RE: CU-14-00005 McDonald Administrative Conditional Use Permit

On October 29, 2014 Kittitas County Community Development Services (CDS) received your application for the above Administrative Conditional Use Permit (ACUP). The application as submitted has been deemed **incomplete** by CDS until such time as the following are submitted:

Drawing file: CU-14-00005 McDonald / CU-14-00005 McDonald Site Plan.pdf

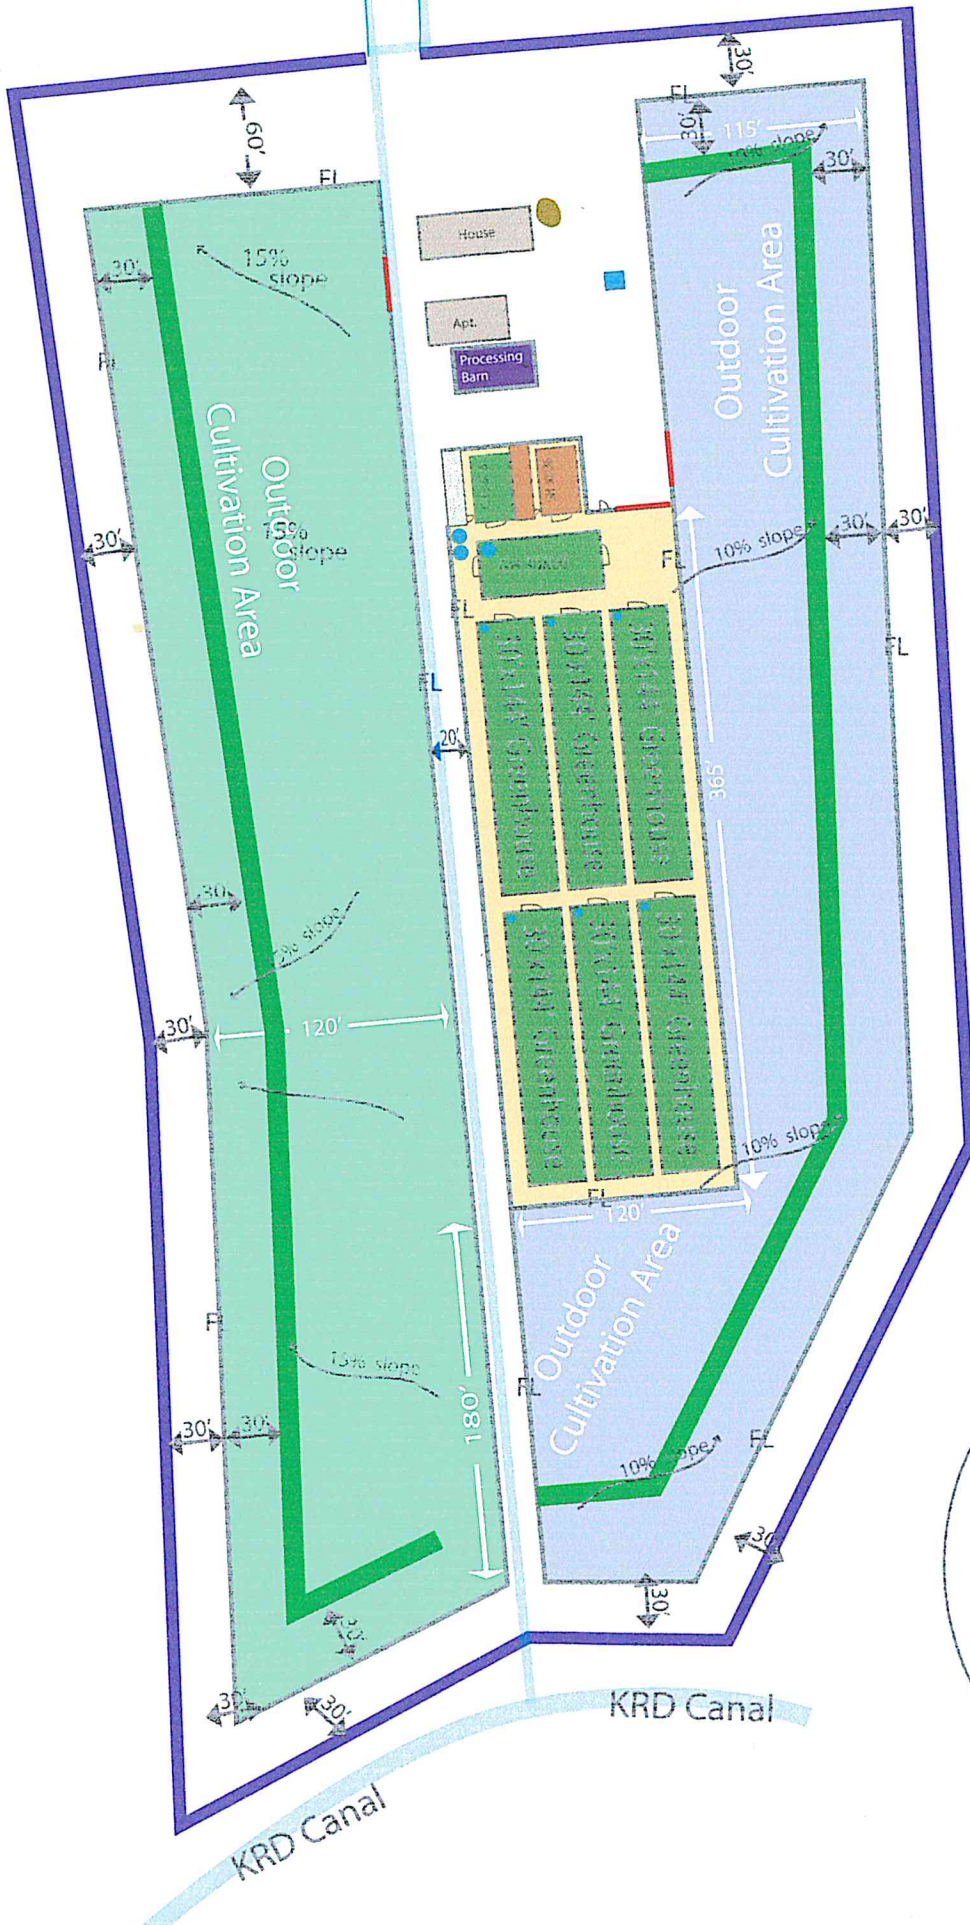
- a. Complete SEPA checklist is filled out in its entirety on a valid SEPA application [WAC 197-11-315\(1\)](#);
- b. Revised site plan depicting :
 1. What Road the subject parcel gains access from;
 2. Label on canal (Owner);
- c. Kittitas County Code (KCC) [Chapter 17.60A.015](#) Questions 1-7.
